Ribble Valley Borough Council  
Council Offices  
Church Walk,  
Clitheroe  
Lancashire  
BB7 2RA

Phone: 0300 123 6780  
Email: [Kathryn.Walsh@lancashire.gov.uk](mailto:Kathryn.Walsh@lancashire.gov.uk)  
Your ref: 3/2024/0214  
Our ref: 3/2024/0214/HDC/KW  
Date: 08 October 2024

**Location:** Unit 45 Mitton Business Park Mitton Road Whalley BB7 9YE  
**Proposal:** Regularisation of change of use from Class B2/B8 (general industrial) to Class E (commercial business and service), provision of mezzanine floor and extension of opening hours to 6.30am to 9.00 pm Monday to Friday, 7.00 am to 4.00 pm on Saturdays and 7.00 am to 1.00 pm on Sundays.  
**Grid Ref:** 372773 437412

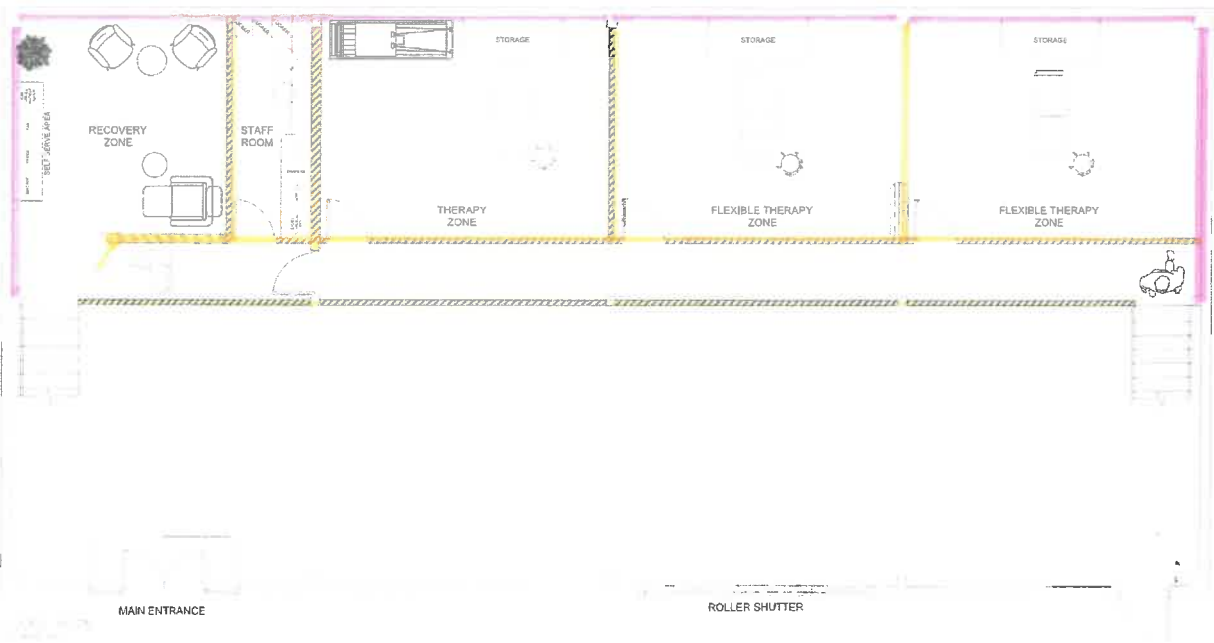
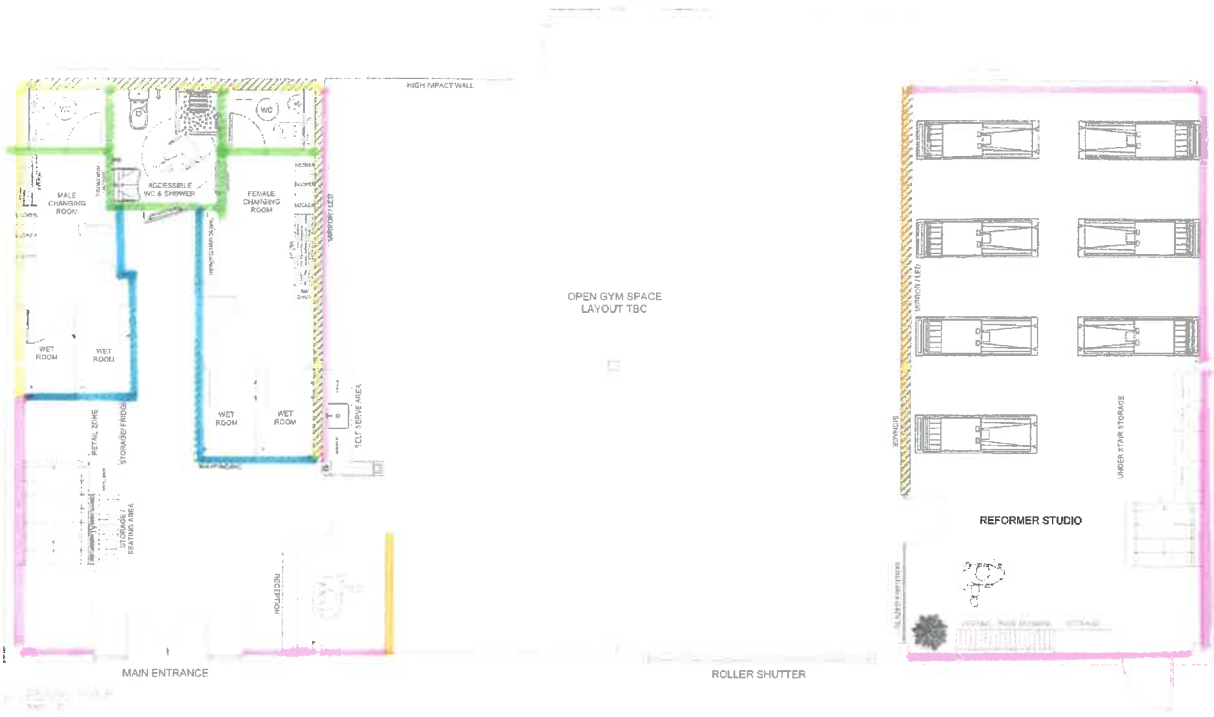
The LHA also requested that clear plans of the existing and proposed internal floor area of the site are provided. The current plans are below standard and the LHA are not able to review the plans appropriately making it difficult for the LHA to assess whether the proposal complies with the LHAs parking guidance.

The LHA therefore request that clear internal layout plans are provided along side an operating statement which demonstrates the operation of the business in line with the existing parking provisions.
